From: Laura Gibbons [REDACTED]
Sent: 21 September 2021 12:27
To: Michael Eastham <Michael.Eastham@arun.gov.uk>
Cc: Paul Cann <Paul.Cann@arun.gov.uk>
Subject: Fwd: *External:FW: FW: *EXTERNAL: RE: Felpham sport changing facilities - FP/248/20/PL

The easement plan shows that it is proposed to extend the swale within the 3m easement from the top of bank of watercourse. The section of extended swale is not acceptable in the location proposed as it will prevent access for maintenance of the watercourse. We request that the proposals are changed to ensure the extended section of swale is not located within the 3m easement.

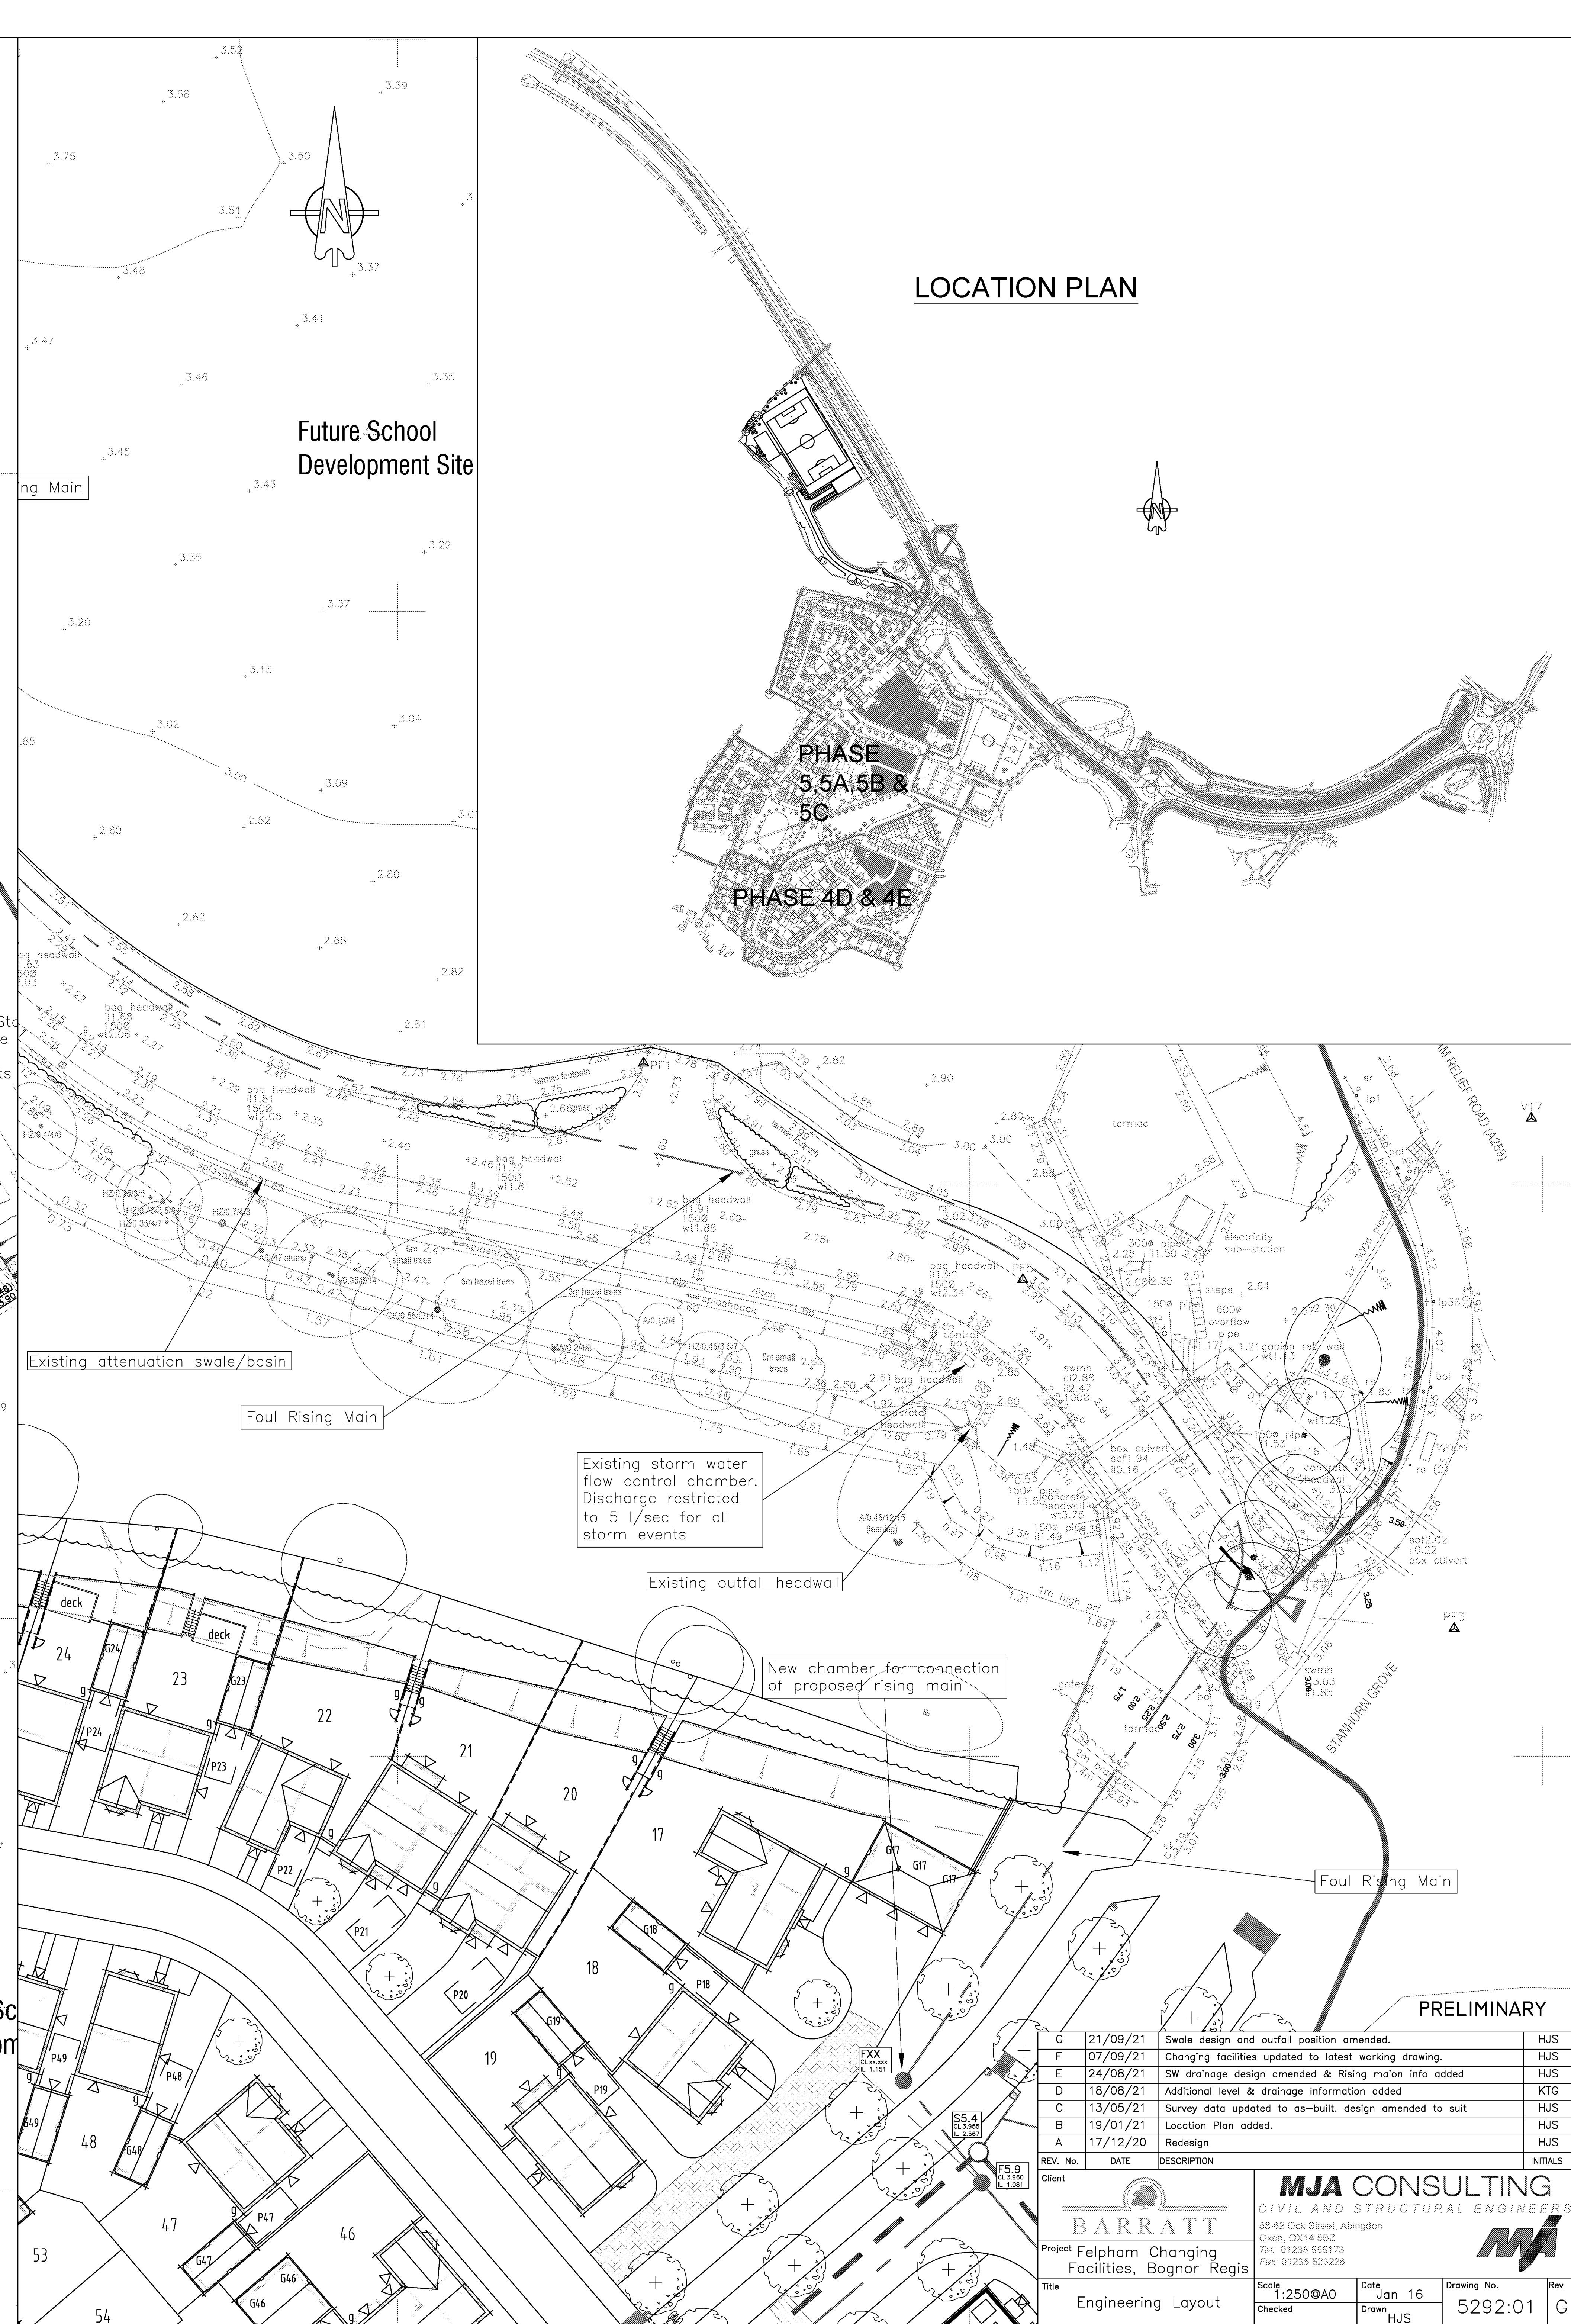
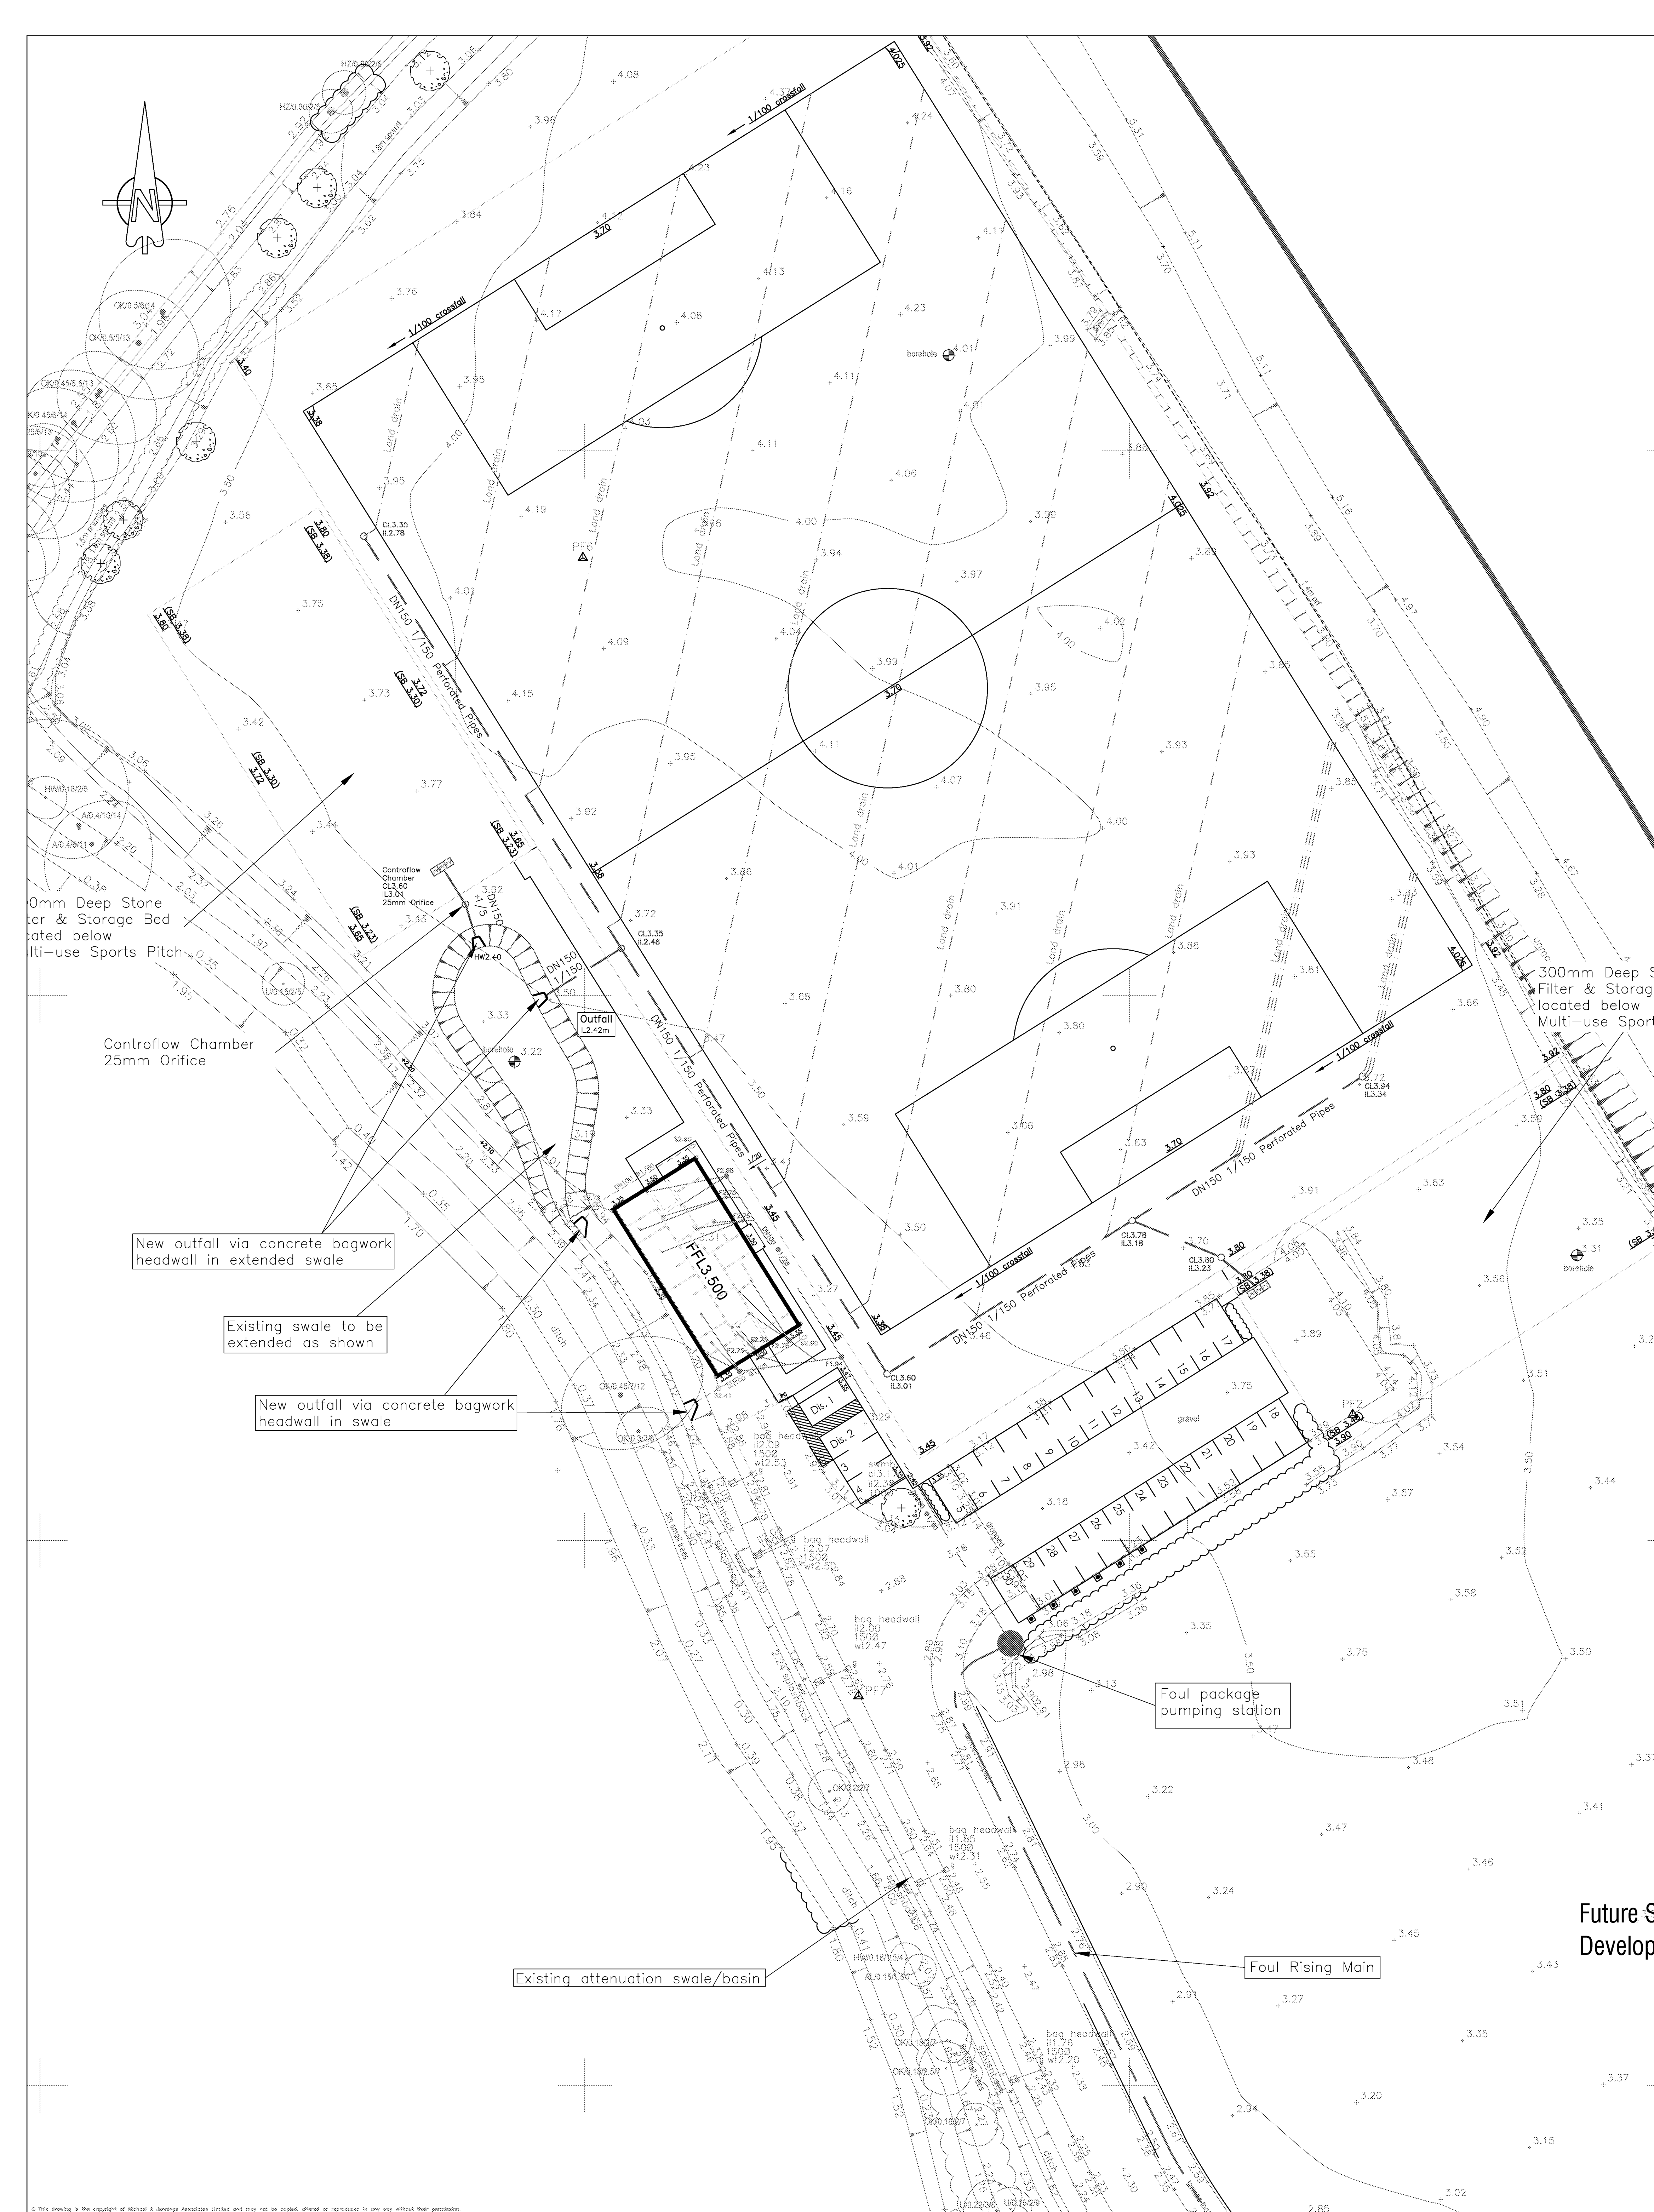
It has not been possible to open the document referred to in the below email. The drainage layout/ engineering drawings should not be listed as approved. We have requested our standard conditions to secure drainage design.
